Appeal Decision

Appeal Ref: APP/R4408/A/14/2223480

Hawthorne House, New Row Lane, Ingbirchworth S36 7GG

HOUSING DEVELOPMENT RESIDENTIAL CURTILAGE AT HAWTHORNE HOUSE
1:500 SITE LAYOUT
DRG A1 11/2013

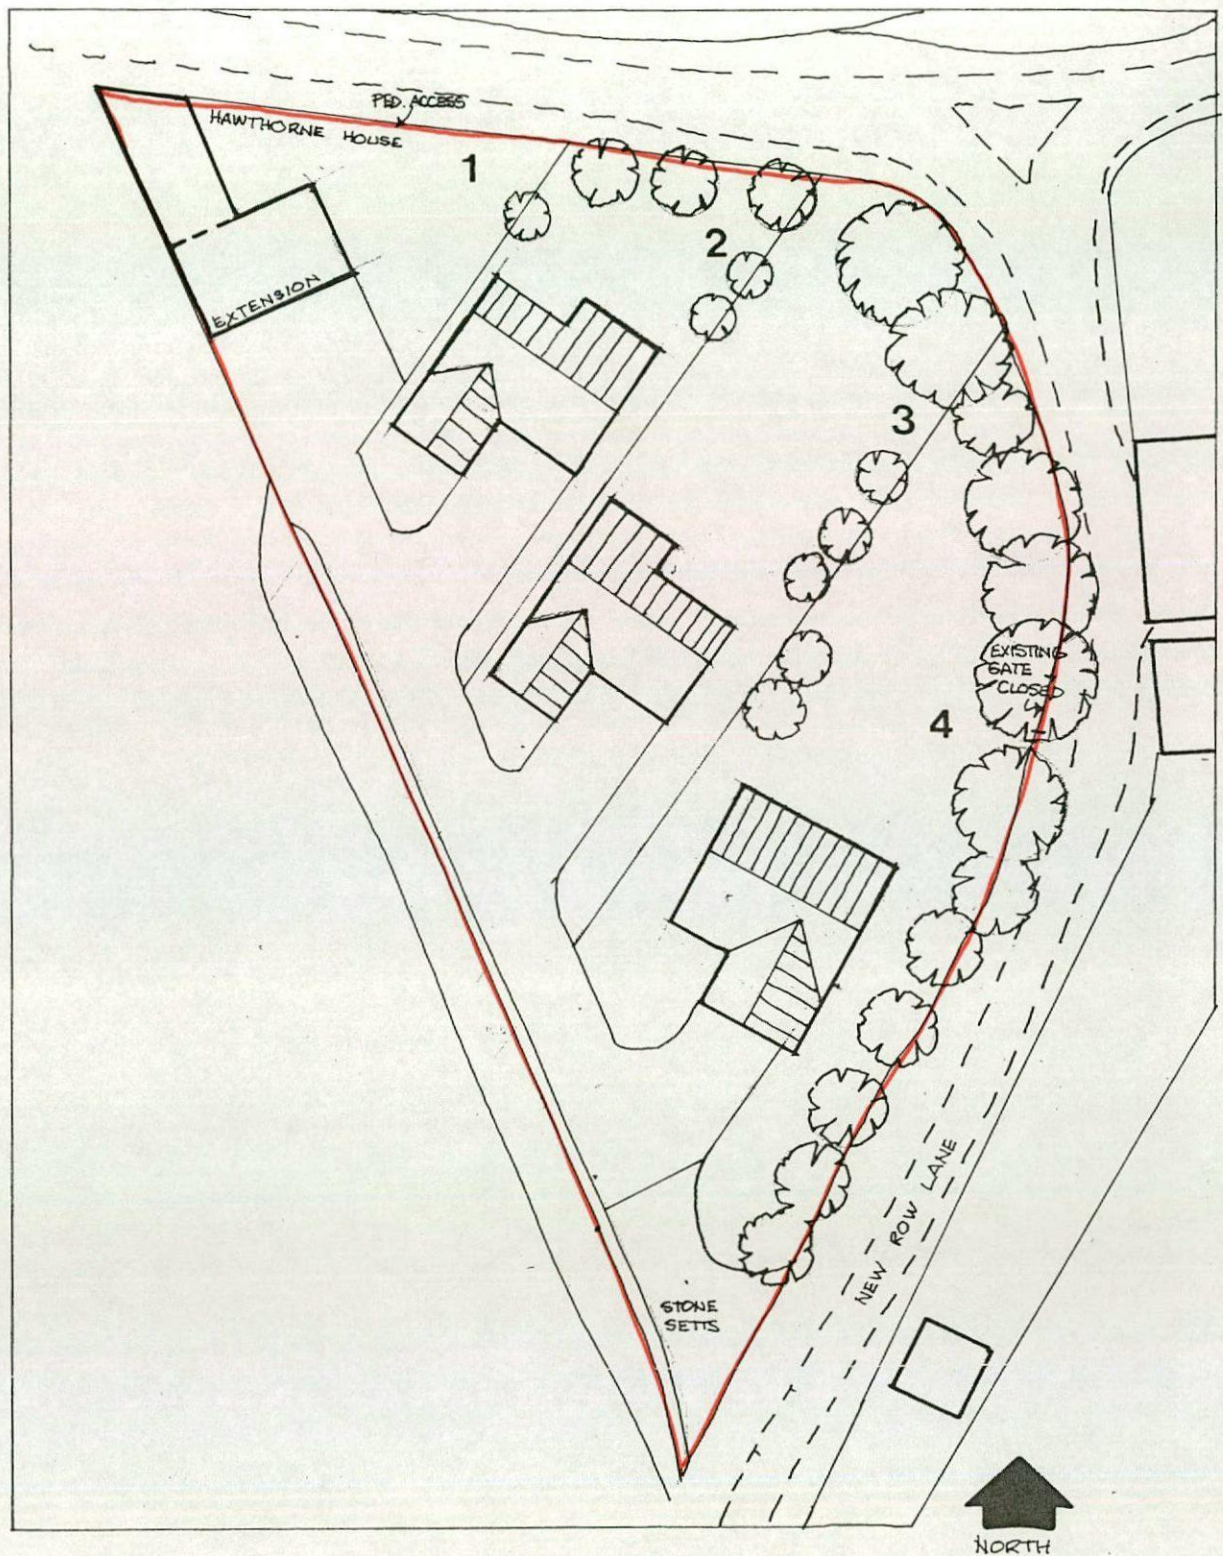
2. The planning application was submitted in outline. The application form indicated that the matter of access is to be considered and that appearance, landscaping, layout and scale are reserved for later approval. The submitted plans included a plan that identified only one vehicular access to the site, the proposed access. This plan also showed an indicative layout of the proposed development including an internal access drive with hard landscaping and the suggested layout of the proposed dwellings.

conservation areas. The DAS indicates that there would be 3 new detached dwellings with 5/6 bedrooms. They would share the new access. Given that the settlement pattern is ribbon like development, where the existing properties mainly face towards the lanes and generally have their accesses, either pedestrian or vehicular (or both) directly onto these lanes, the appeal scheme would create an atypical form of development on the basis that one access point off the lane would provide vehicular access to 4 dwellings. This would not reflect the established historic settlement pattern in the locality.

12. In addition, the proposed access would serve the 3 proposed dwellings and Hawthorne House when typically dwellings in the ICA are served by individual accesses directly off the network of roads and lanes. Such a development would be discordant with the historic arrangement of the settlement. From the information submitted, the proposed scheme would not relate to the local character in terms of the existing built form and grain in this rural locality.

15. The Highway Authority raises concerns that the proposed access would not be perpendicular to New Row Lane and that the required visibility distances would not be achieved on the basis that manoeuvrability standards through accesses are based on a 90-degree angle of exit and entry.

17. The Highway Authority also states that the proposed access would not be wide enough to allow for 2-way access or that there would be adequate space for turning within the appeal site. It goes on to state that vehicles would need to reverse back onto New Row Lane if the entrance was blocked by exiting vehicles or would not be able to exit in the forward gear if no turning facilities were provided within the appeal site.

18. Whilst the appellant states that the proposed access junction would meet all the required highway safety standards, from the evidence provided I do not consider that this has been adequately demonstrated. Given the narrow road width, the horizontal and vertical alignment of the road, which includes a sharp bend to the south of the proposed access, and the constraints of the appeal site, I am not convinced that these standards could be achieved and that the proposed access would not create a highway hazard. This could be significantly detrimental to highway safety.
